From: Anita Gardner
Sent: 01 May 2012 11:15
To: Planning.Responses
Subject: FW: LU/52/12 Provision of new floating pontoon accessed via 5 no. access ladders from approved projecting balconies 47 River Road, Littlehampton

From: Anne Carnegie [mailto:anne.carnegie@littlehampton.org.uk]
Sent: 01 May 2012 09:14
To: Anita Gardner
Cc: Lee Harrison
Subject: RE: LU/52/12 Provision of new floating pontoon accessed via 5 no. access ladders from approved projecting balconies 47 River Road, Littlehampton

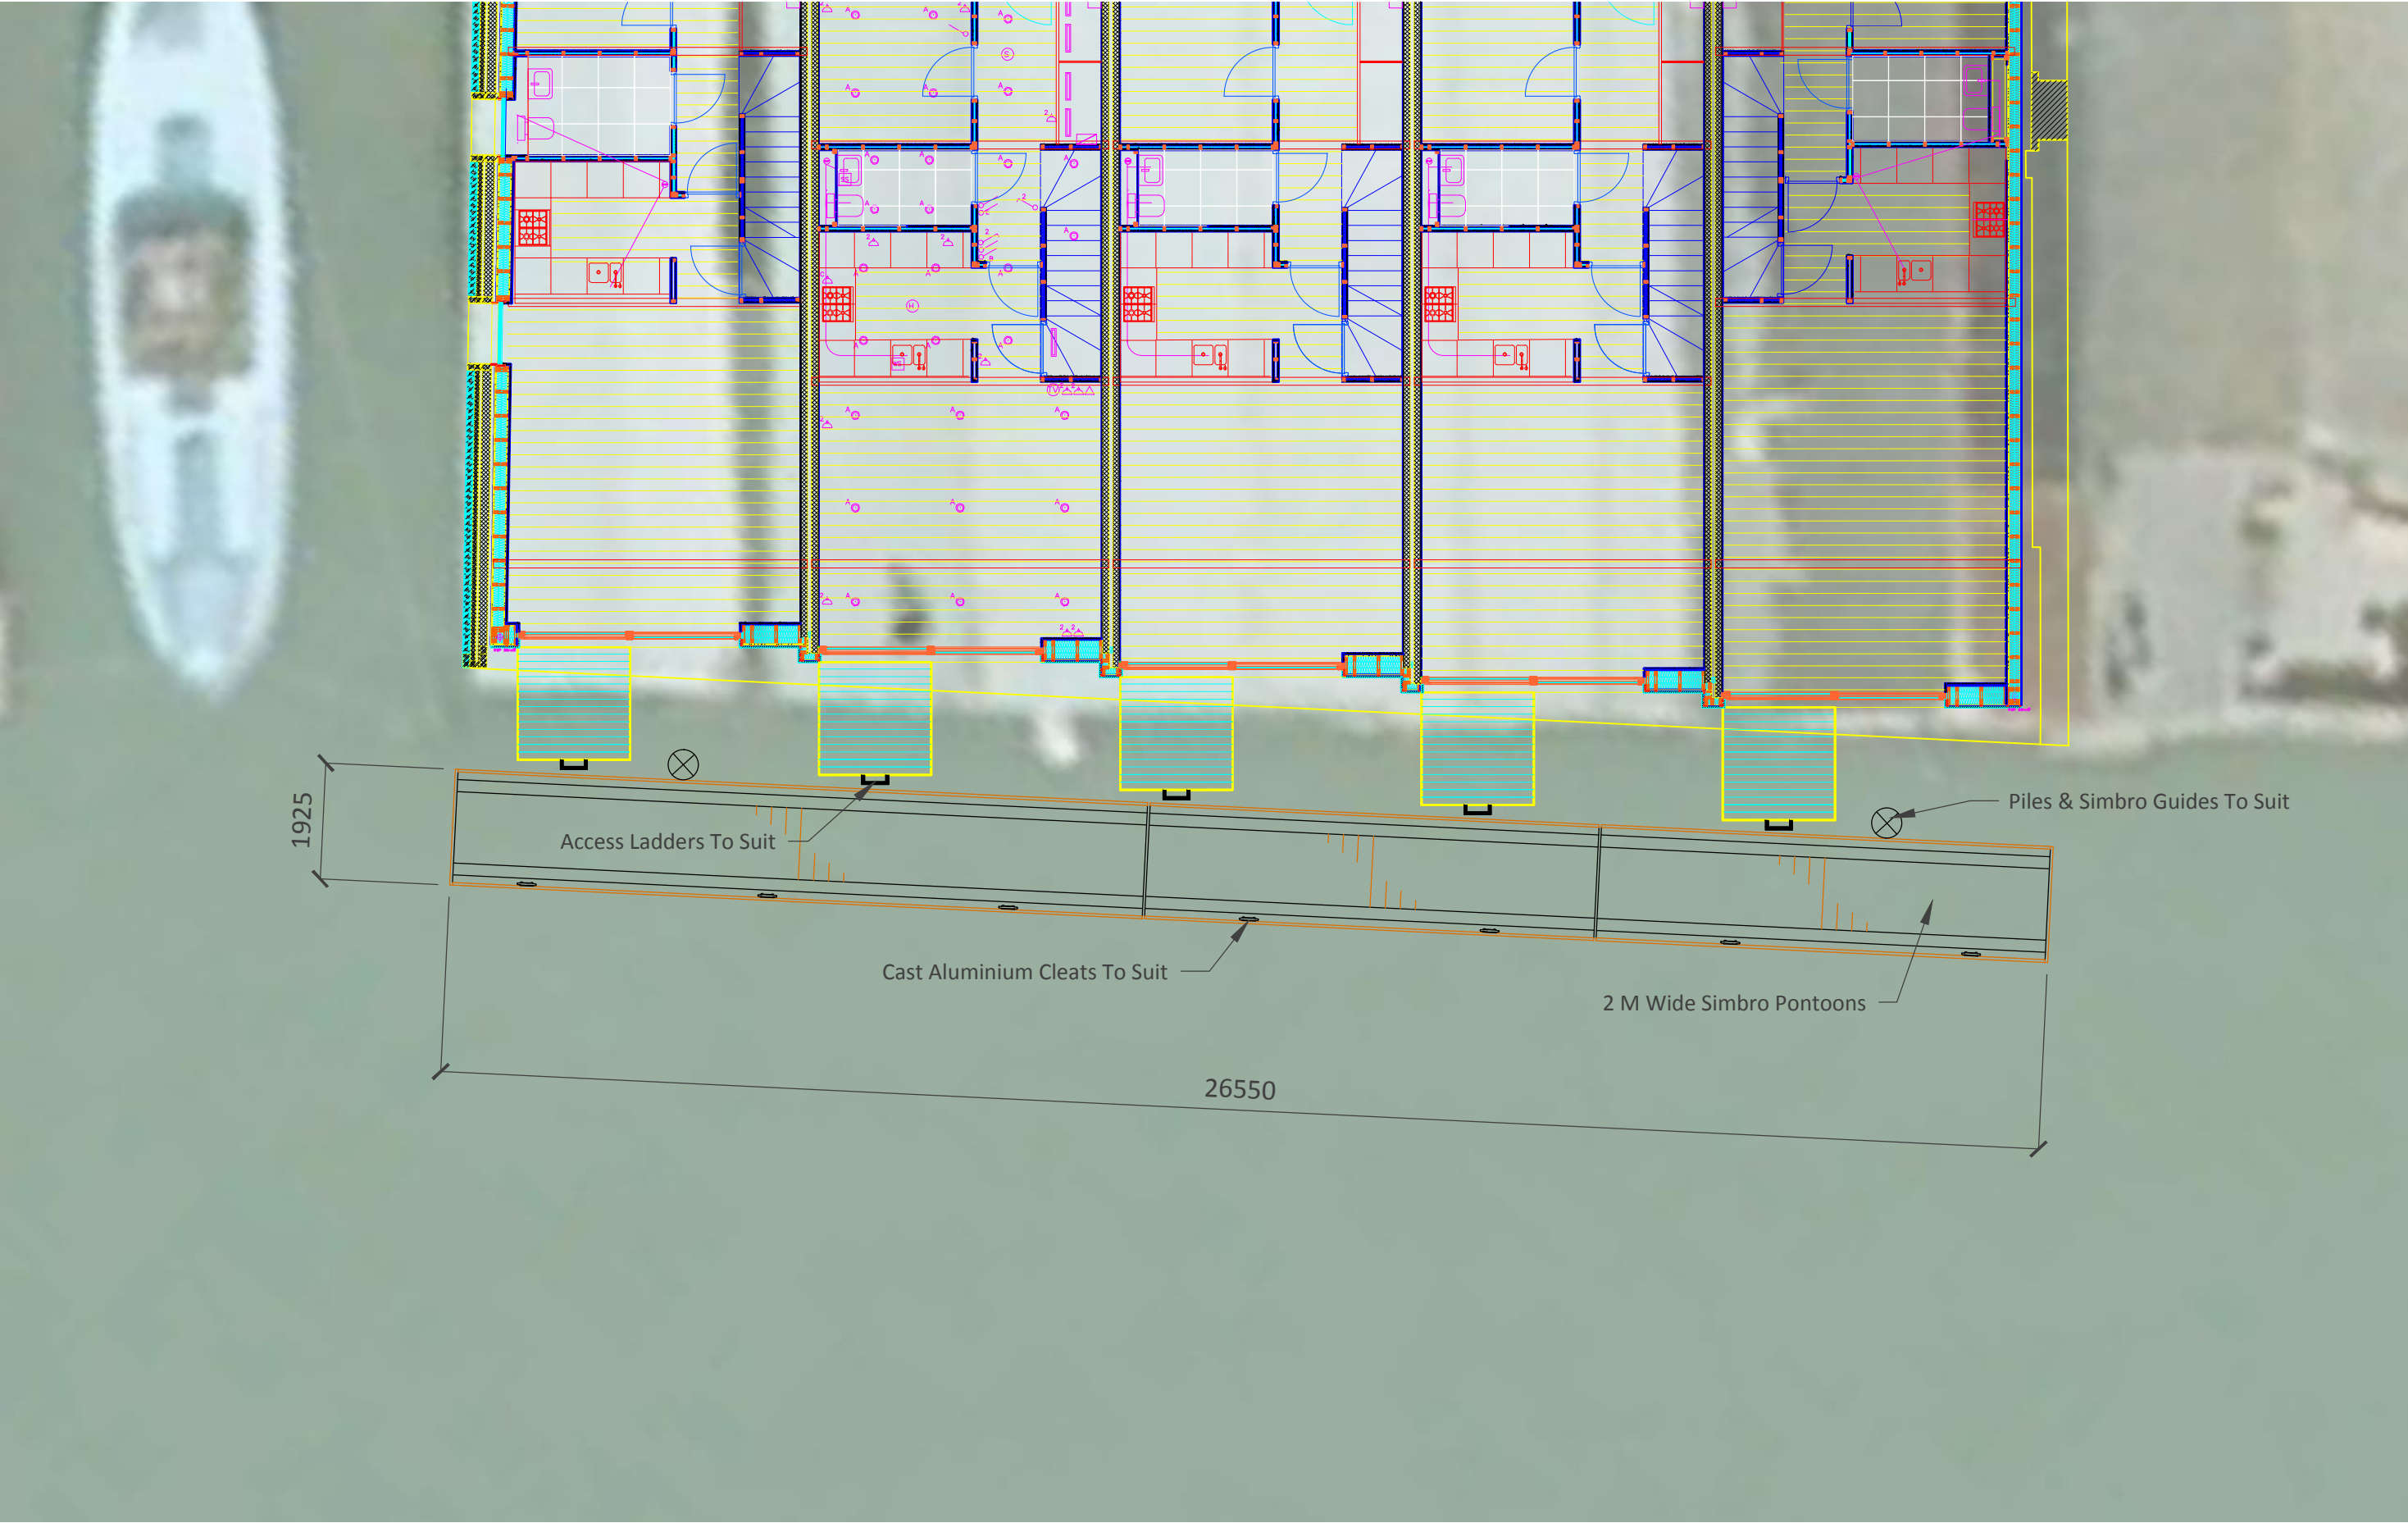
Thank you for contacting me. I had extensive correspondence with the architects about the projection of the pontoon into the river before the plans were submitted to ADC and having viewed the planning application, I am relieved to see that they have complied with our request that the "maximum distance from the existing wall at 47 River Road to the outboard side of any moored vessel at this location should be no more than 6.7m".

The plans show the outer edge of the pontoon is 3.6m from the edge of the building so this allows for a maximum beam of 3.1m which is a sensible allowance for this location.
